Medworth Energy from Waste Combined Heat and Power Facility

PINS ref. EN010110
Document Reference: Vol 9.20
Revision: 7.0
Deadline 7
August 2023

Schedule of Changes (Deadline 7)

March 2023

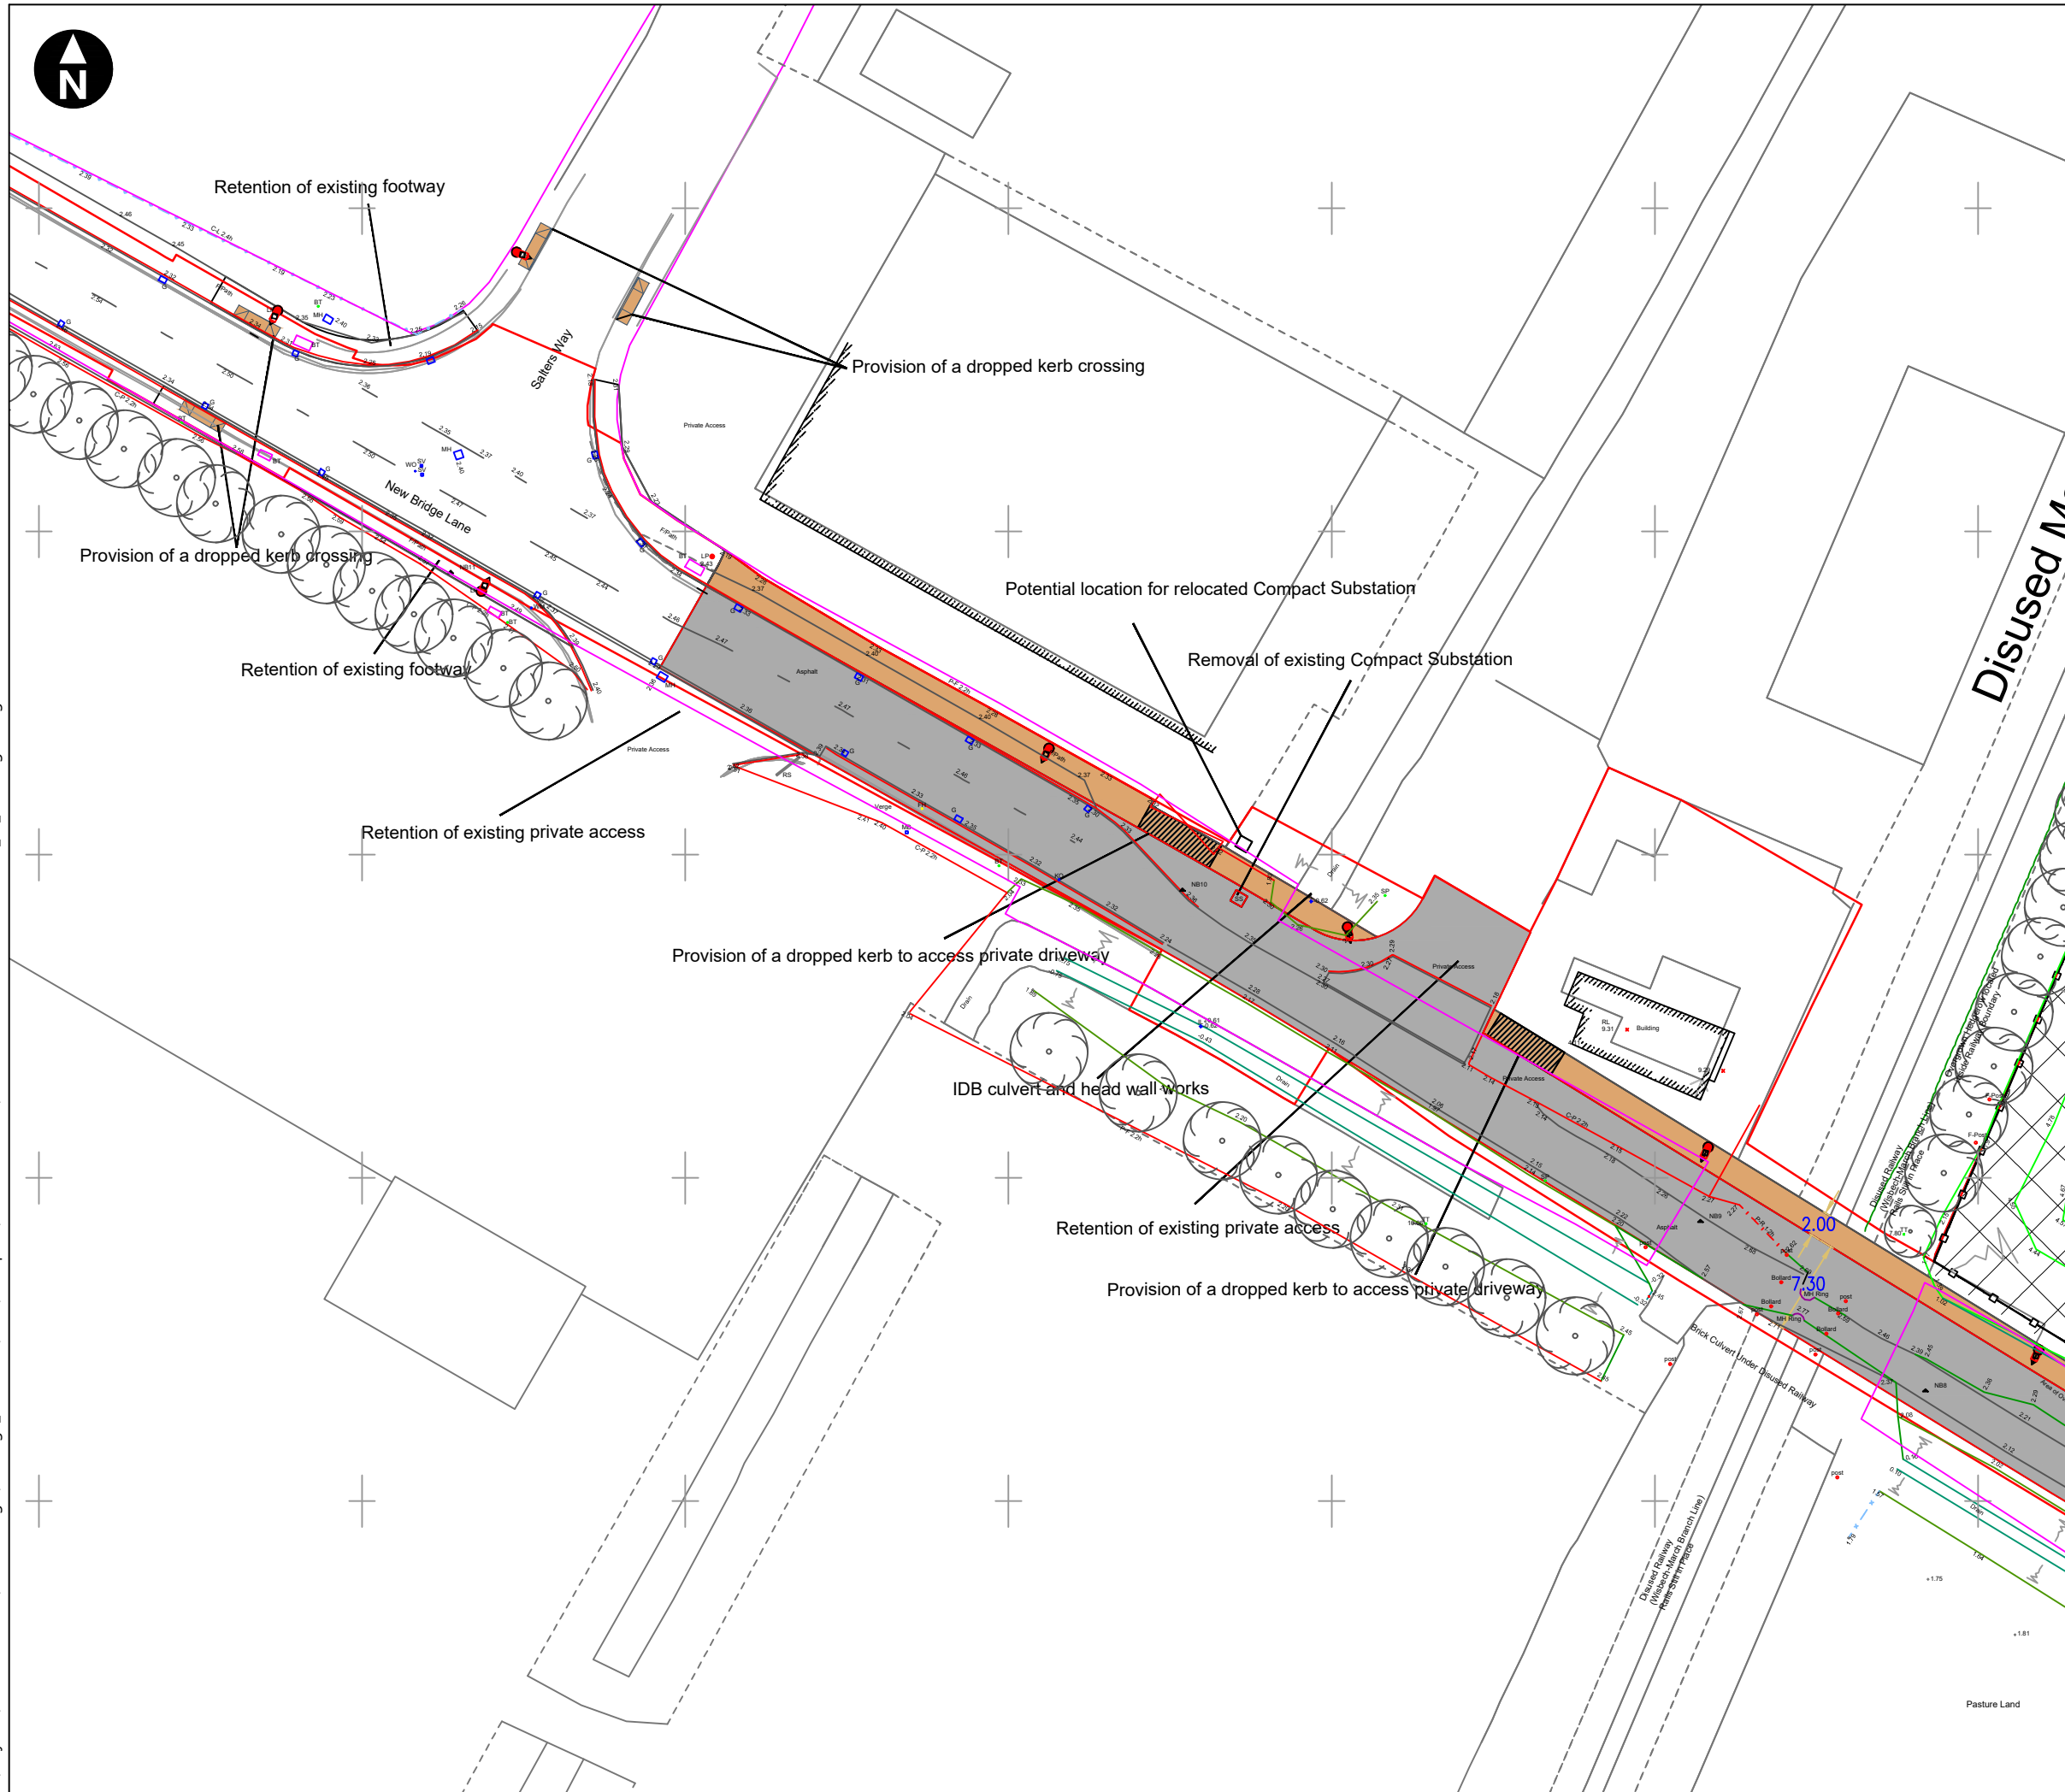
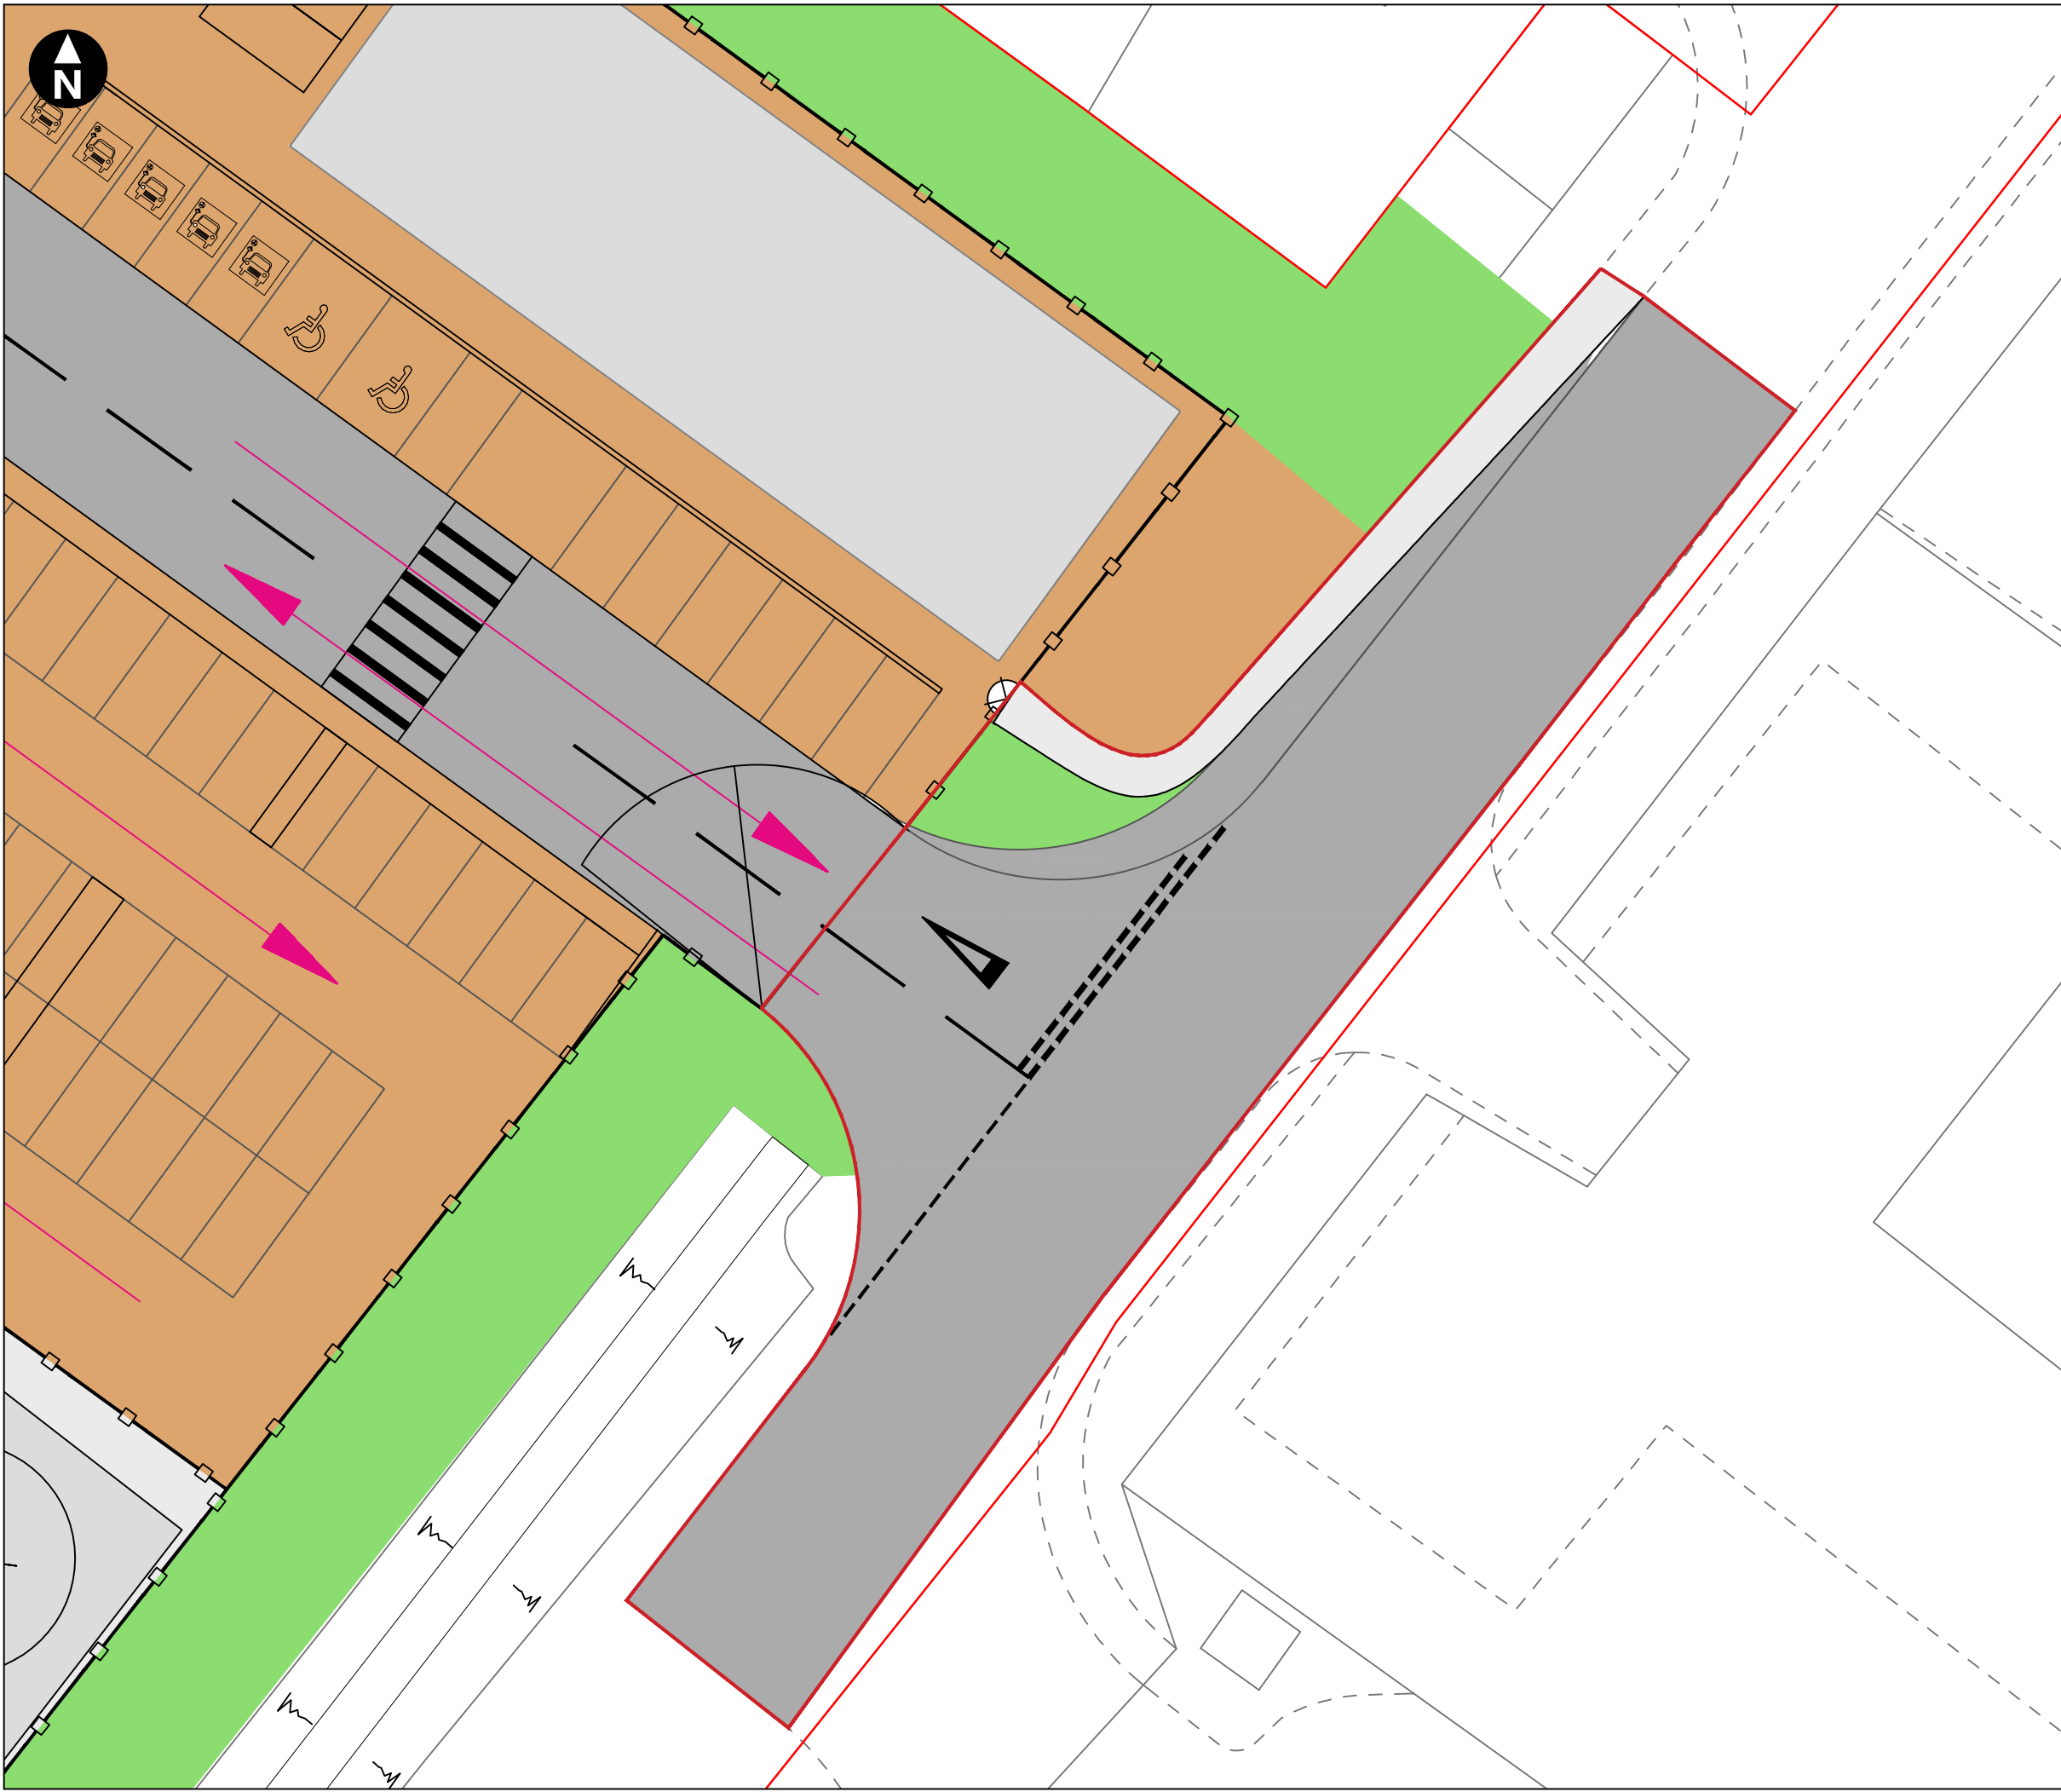
Volume 6.4 ES Chapter 6 Traffic	Additional drawings, Figures 9.2ii to show swept path of vehicle leaving New Bridge	CCC and FDC LIR paragraph 2.7.32 and 2.7.34 [REP1-074] .	Deadline 3	Rev 3

Document Updated	Change	Reason for change	Deadline submitted	Relevant Document version
and Transport Appendix 6A Outline (CTMP) [REP1-011]	Lane. Also Figure 10.3i – ii to show outline design for construction accesses into the CHP Connection Corridor from Weasenham Lane and accompanying swept path.			
Volume 6.4 ES Chapter 7 Noise and Vibration Appendix 7D Outline Operational NMP [REP1-012]	Reference to Applicant's intention to purchase 9 New Bridge Lane updated to confirm that the property has been purchased. Additional text added to 5.1.2 to include for the submission of a report to the relevant planning authority detailing the height, materials and acoustic performance of the acoustic fence to 10 New Bridge Lane for agreement ahead of construction.	CCC and FDC Comments on the Applicant's D1 Submissions (Outline CEMP) [REP2-031]. Outline Operational Noise Management Plan.	Deadline 3	Rev 3
Volume 6.4 ES Chapter 7 Noise and Vibration Appendix 7D Outline Operational NMP [REP1-012]	New paragraphs 1.4.8 and 1.4.9 to provide a commitment to the preparation of an Operational Noise and Vibration Management Plan for the Walsoken Substation.	KLWN Relevant Representation [REP2-028].	Deadline 3	Rev 3
